From: Anita Gardner <Anita.Gardner@arun.gov.uk>
Sent: 24 July 2020 08:18
To: Planning.Responses <Planning.Responses@arun.gov.uk>
Subject: FW: AB/63/20/DOC - Materials

From: Pendry, Glenn [REDACTED]
Sent: 24 July 2020 07:25
To: Anita Gardner <Anita.Gardner@arun.gov.uk>
Cc: 'Lynnette St quintin' [REDACTED]
Subject: AB/63/20/DOC - Materials

Subject: *EXTERNAL: AB/63/20/DOC - Materials

Material Schedule
 Vert tile hanging
 Multi Stock main Brick
 Red brick Plinth
 Red brick sills
 White UPVC windows
 Concrete Roof Tiles

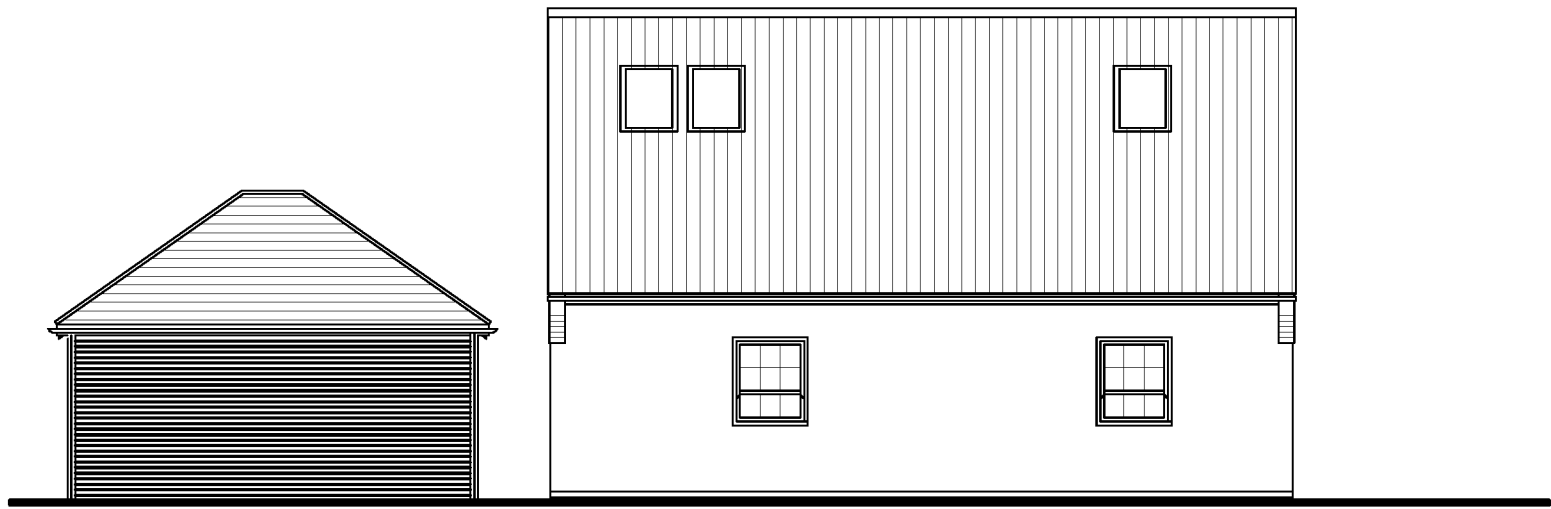
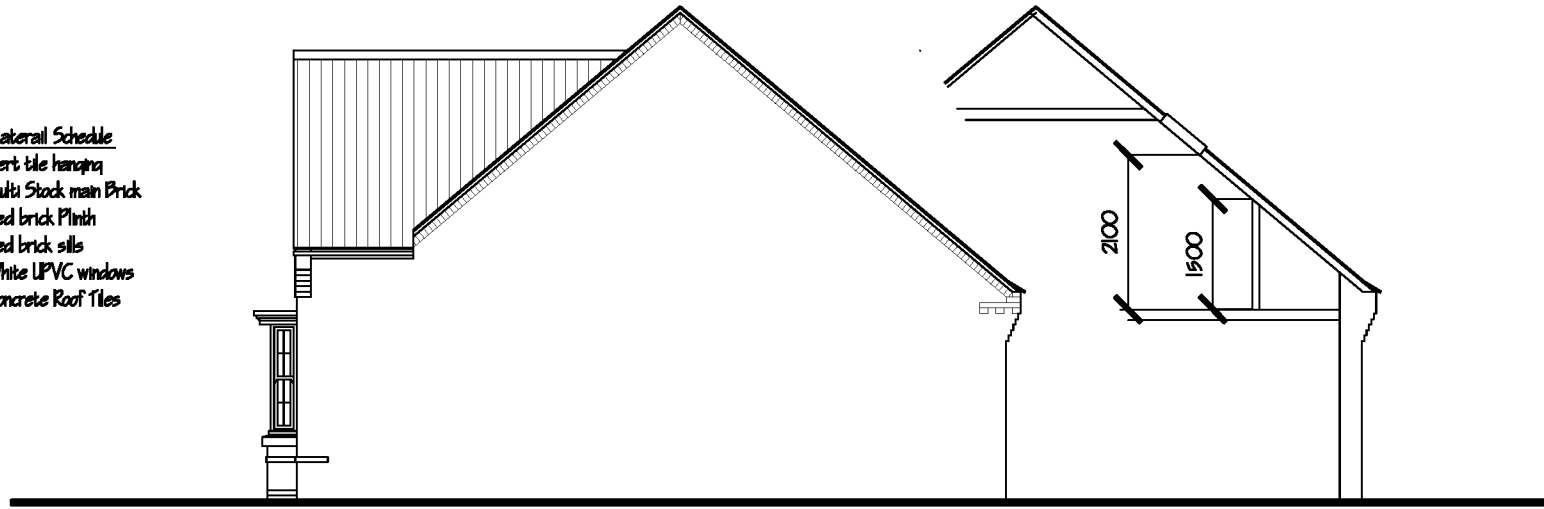
I have considered the submitted materials and agree that the suggested brick is suitable. I also have no objection to the type or profile of tile requested, but would suggest that an alternative colour is considered. The area is dominated by red/brown tiles and grey would not reflect this. Please can you confirm whether you would be prepared to consider an alternative and if so which colour from the range?

In relation to the tile colour, please see alternative proposal below for your consideration.
